From: Simon Davis
Sent: 17 April 2020 13:27
To: Ben Daines [REDACTED]
Cc: Chris Barker [REDACTED]
Subject: RE: BE/137/19/RES

Drawing Title
Detailed Site Plan

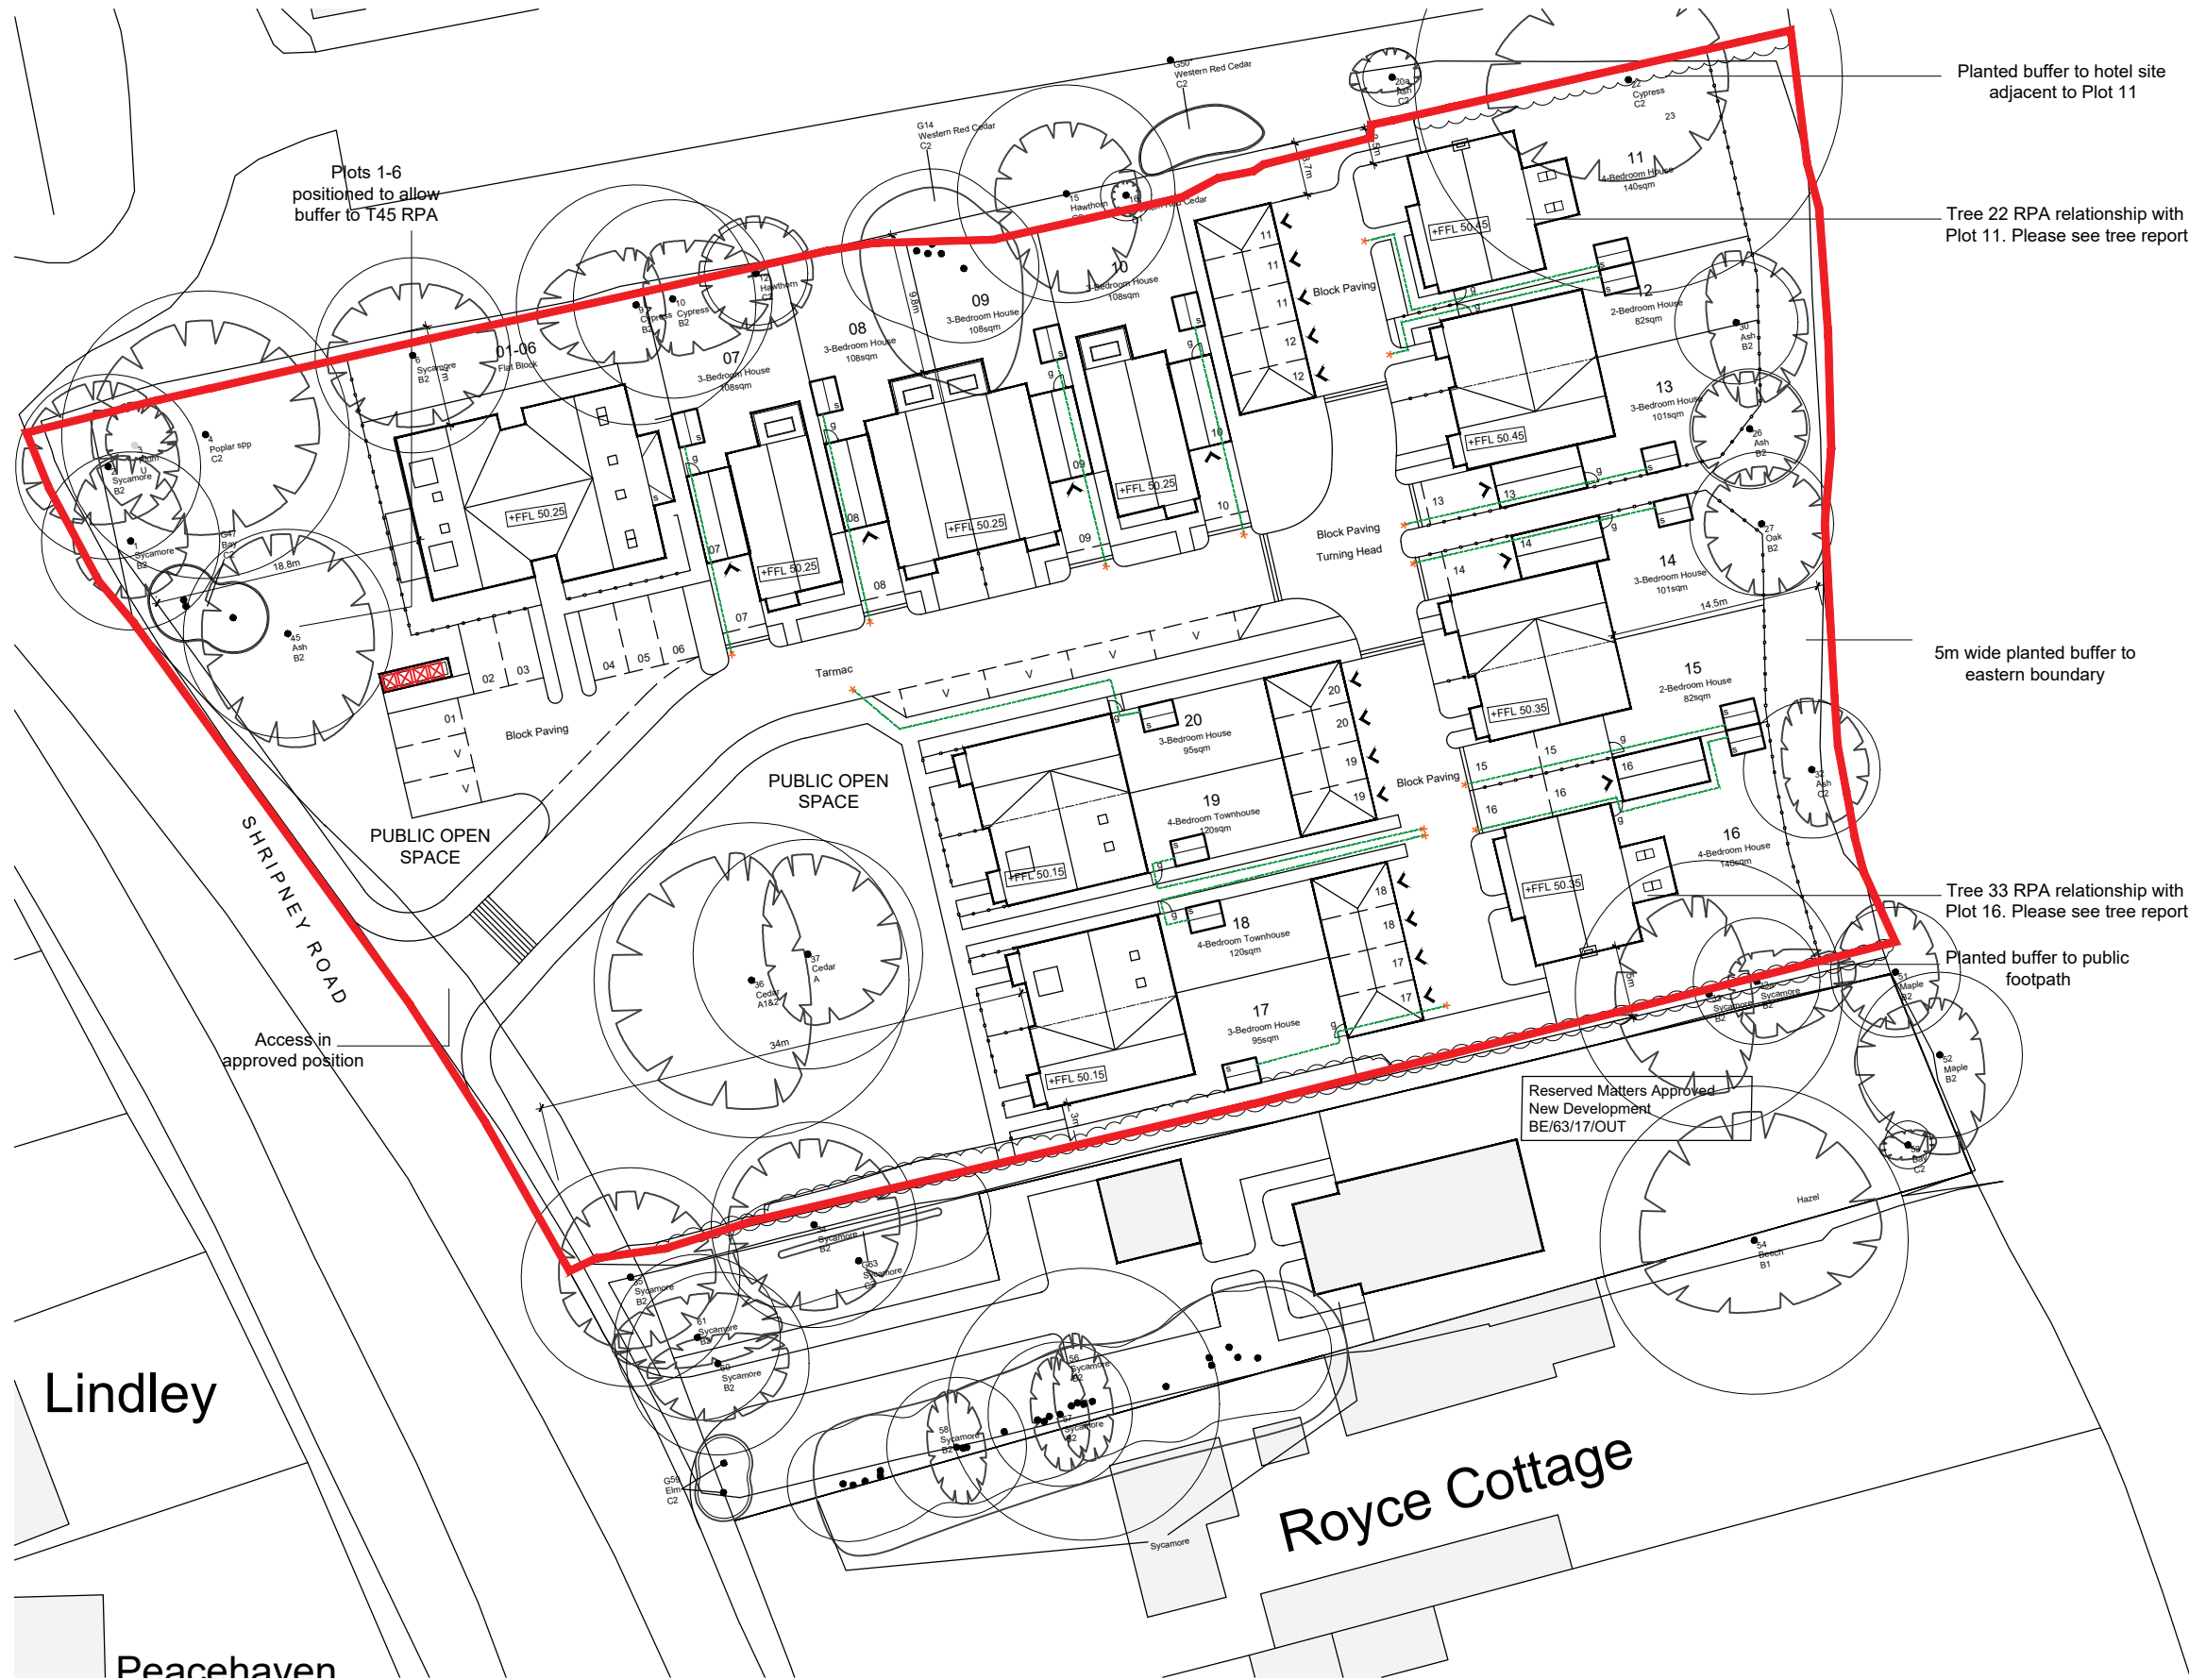
On parking, I calculate the new requirement to be 46 spaces total (42 + 4 visitor) and see that you propose 43.5 (with the half a result of garages treated as 0.5 a space each). I note that you have removed the pathway between 18 & 19 and gained an extra visitor space which is good. I would suggest that you do incorporate secure rear doors on the car ports for plots 17-20.

You will see that the layout has been amended to ensure that all of the dwellings are no further into the RPA of the existing trees than the approved outline consent. You will also note that in a number of cases the dwellings have been moved further from the trees than the outline consent. The approved outline site layout is shown by a purple dotted line overlaid onto the proposed amended site layout. Could you please send this to the tree officer for comment and if you and the tree officer are happy with the amended layout we will finalise the revised AIA and Method Statement and submit the amended coloured site layout formally. I appreciate that the tree officer will want to see the AIA before removing any objection but presumably they can provide an indication at this stage as to whether they are likely to support the scheme.

You will note that we have two additional parking spaces and have changed dwellings 18 and 19 from 4 bed dwellings to 3 bed dwellings. Please confirm that this now meets the Council's parking standards and we will submit the amended plans and elevations for these units.

Having regard to the comments raised by WSCC regarding the visitor spaces to the north of Unit 20, we do not really consider this to be an issue and parking restrictions would seem heavy handed. Surely there are significant incentives for the occupiers of Units 17 to 20 to park their cars within the car ports at the rear of the properties i.e. protection from the elements and other cars which may be parking in these spaces. The distance from the car ports to the front doors of the dwellings is certainly not excessive but we would be willing to add doors in the western elevations of the car ports to allow people to access their properties from the rear if that would help address the issue.

Excluding Area A from our calculations, as per your emails of 12 March, we are providing 1,333sqm of open space which is about 75sqm under the requirement. I trust you will agree that this amount is negligible. We could increase the amount of public open space slightly by reducing the size of the gardens for plots 17 to 20 but this would seem counter-intuitive and unnecessary.
